I-25 / Palmer Ridge Road
El Paso County

May 29, 2025

RE: Monument Ridge East Filing No. 1 (SF2514)
Monument Ridge Metropolitan District Nos. 1-3 (ID245)

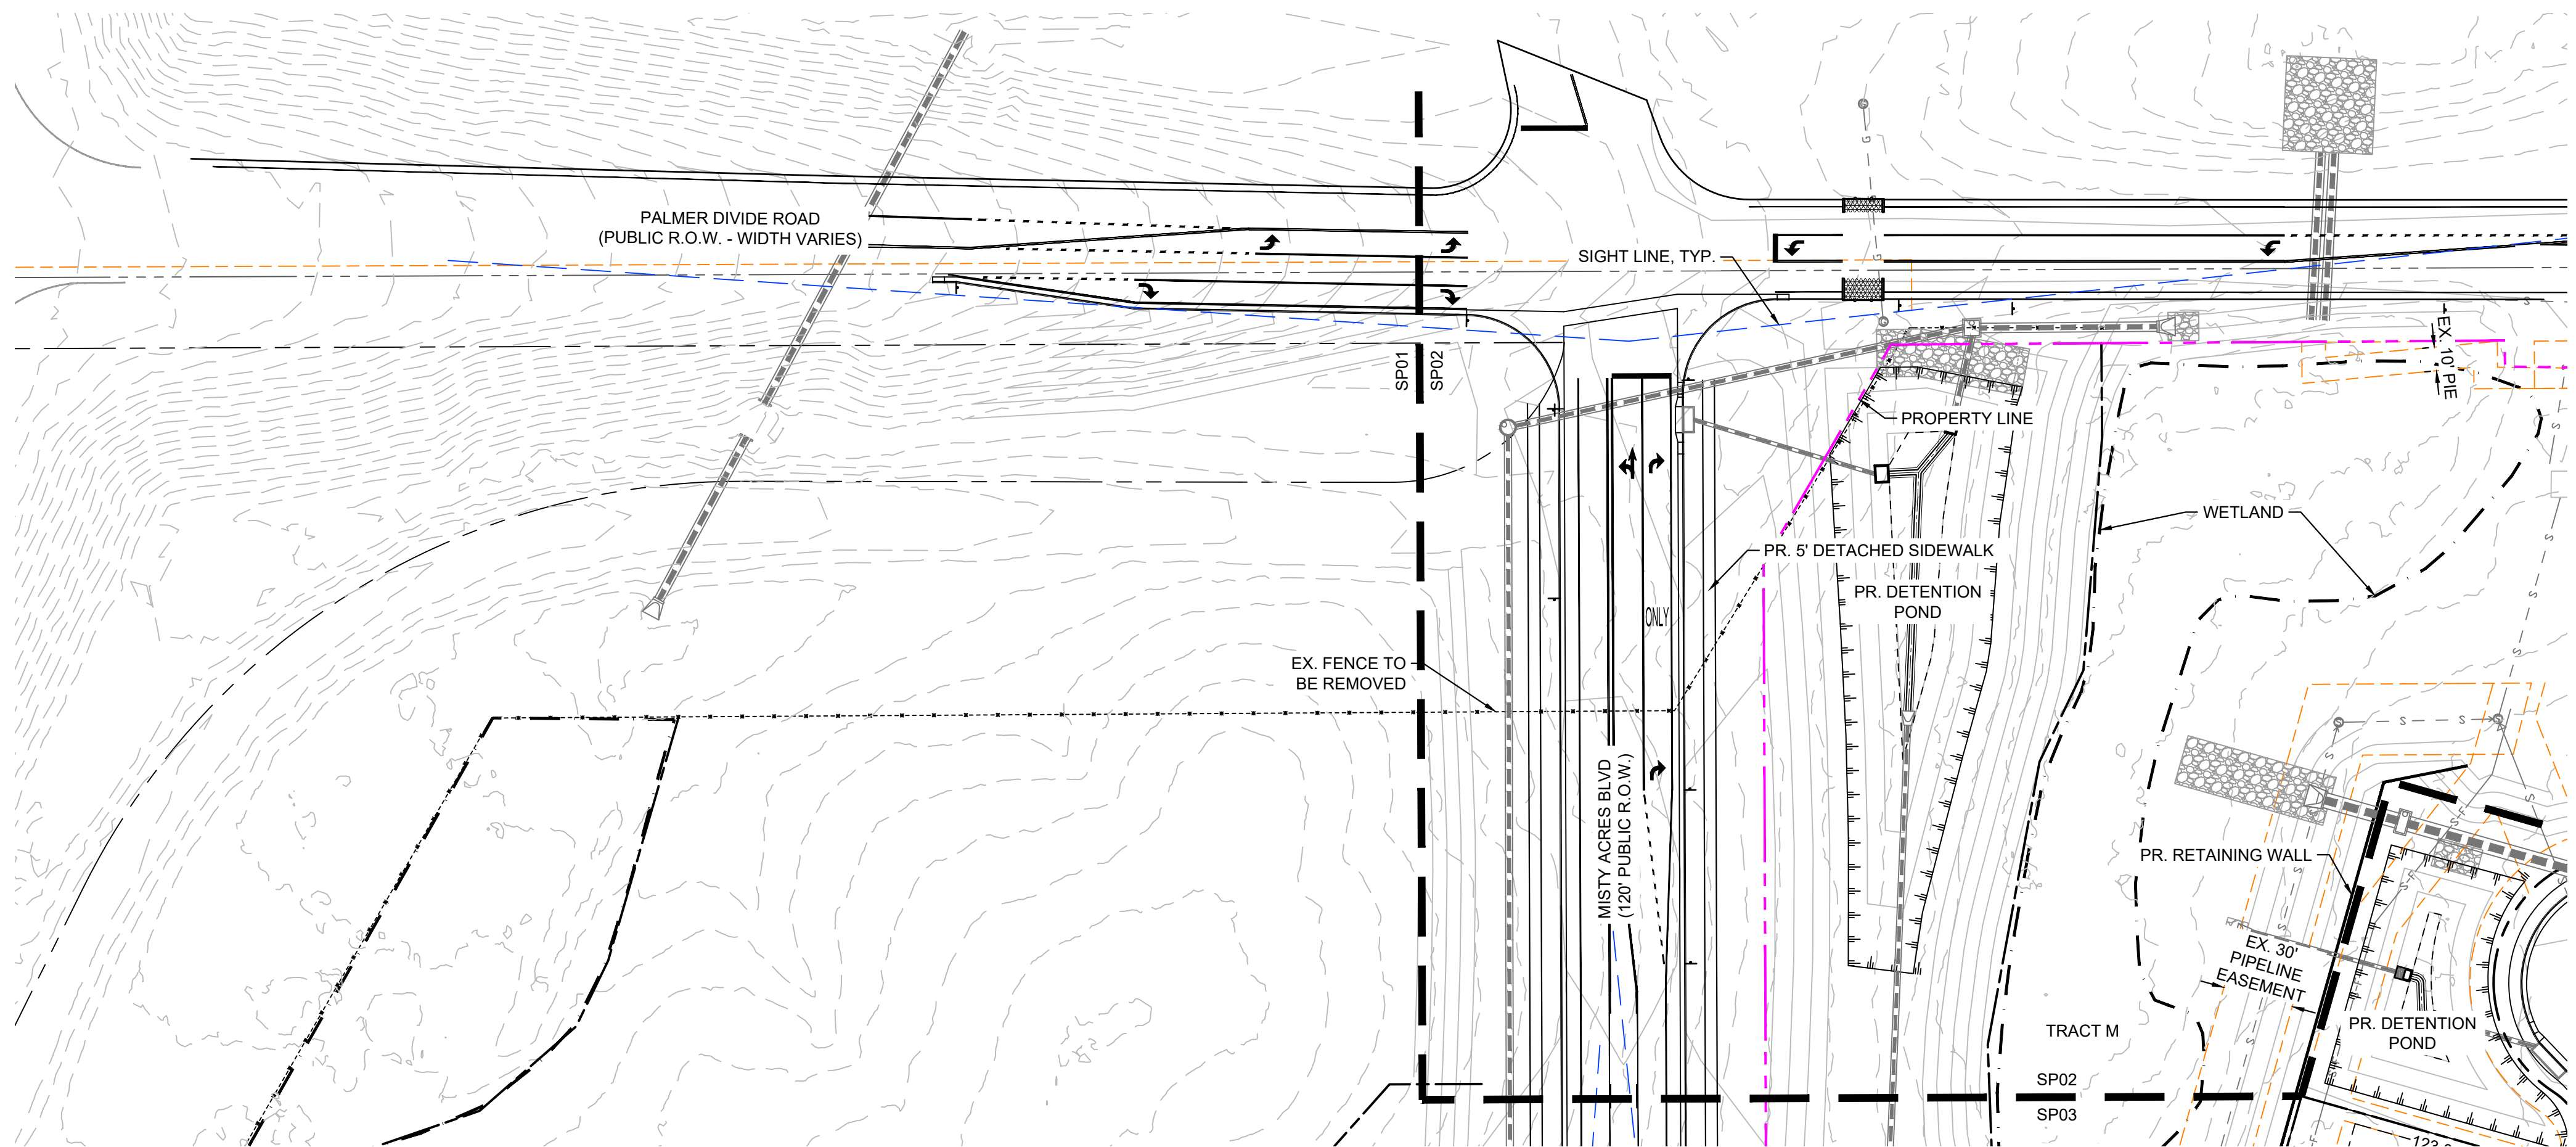
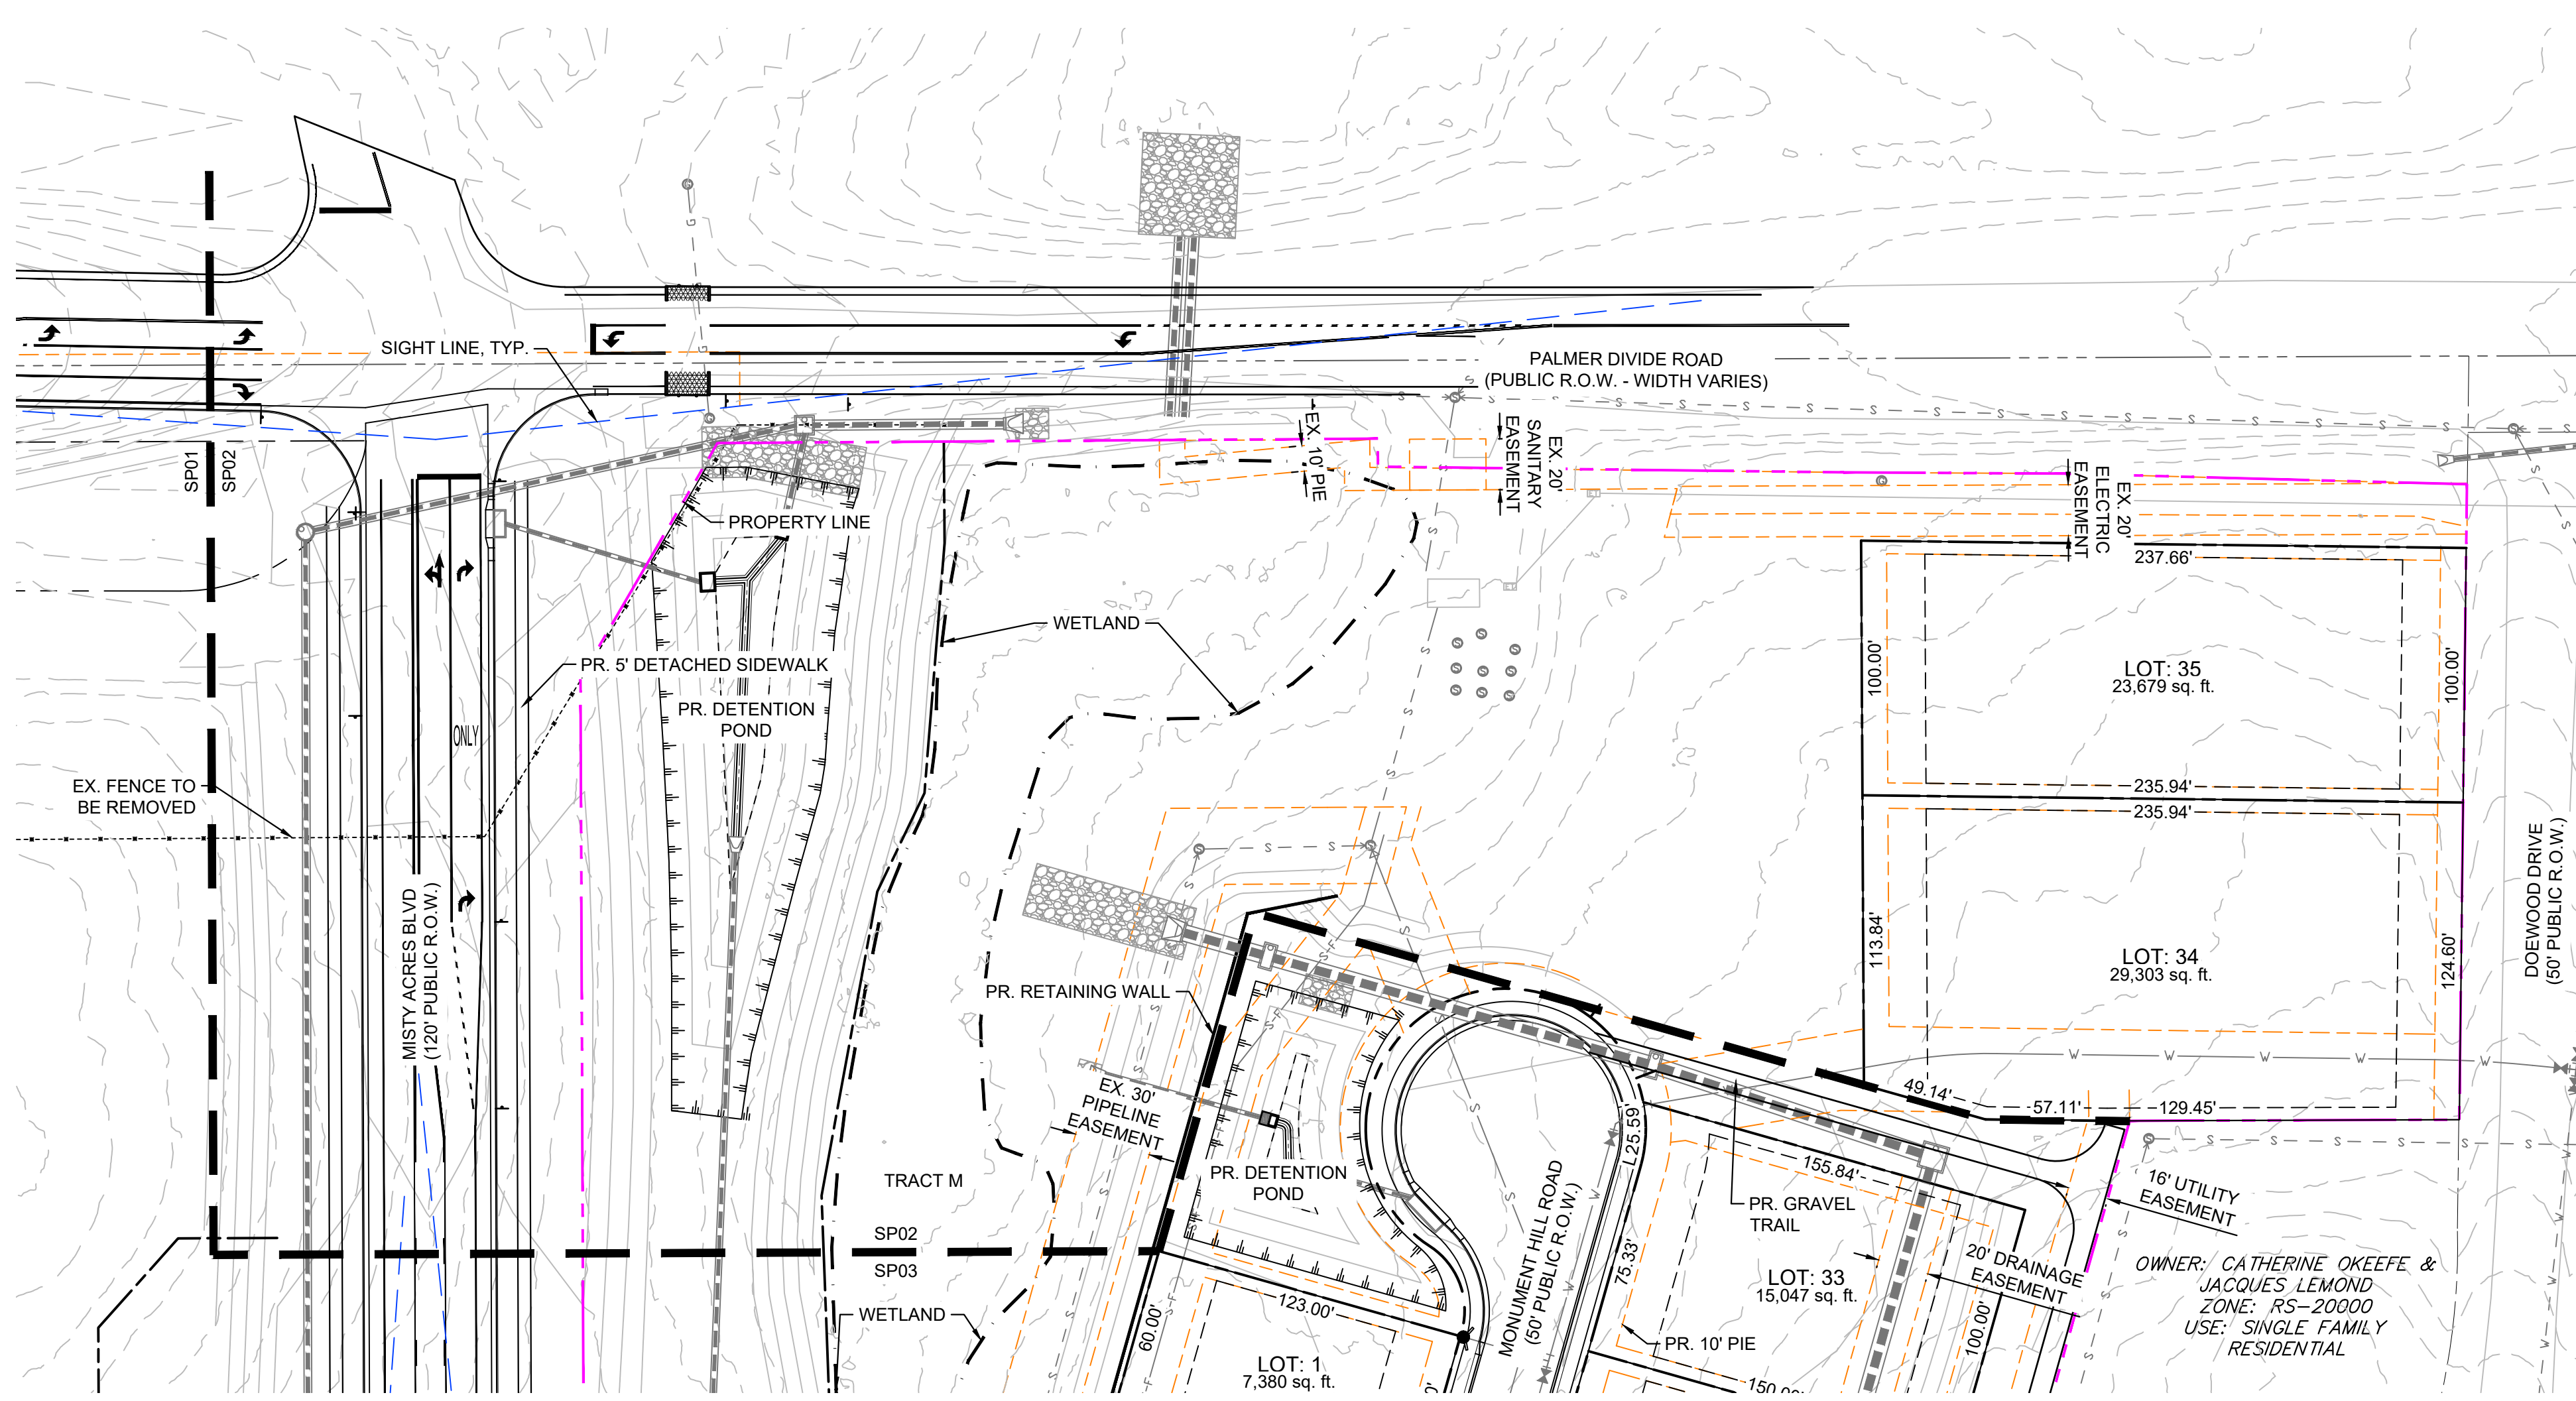
- The Development Plans have a new access from the I-25 Frontage Road. This access is north of the existing deer guard (labeled as a "Cattle Guard" in the plans). If the access (labeled as "Catch slope") is to be constructed, the new driveway will require a new deer guard (similar to the deer guard present) to prevent animals from entering the I-25 corridor. A new deer guard would need to be adequately sized in accordance to the new driveway width. Also, the current placement of the deer guard was solely placed to access this property.

- The Development's connection to East Palmer Divide Ave (not the frontage road) appears to be directly on the existing Deer Guard. This is not shown in the plans. The double CMP are shown, but not the deer guard. The deer guard shall remain in place. A new deer gaurd is suggested since the driveway will create a new access point for deer and elk to enter the highway corridor. This Deer Guard is owned by El Paso County.

- There are no details of how the new proposed access points will connect to the existing wildlife fence.
- Cannot see details or how the new driveway on the north end of the property will accomodate the Monument Hill Road Frontage Road. Looks to be a traffice conflict with driveways being very close.
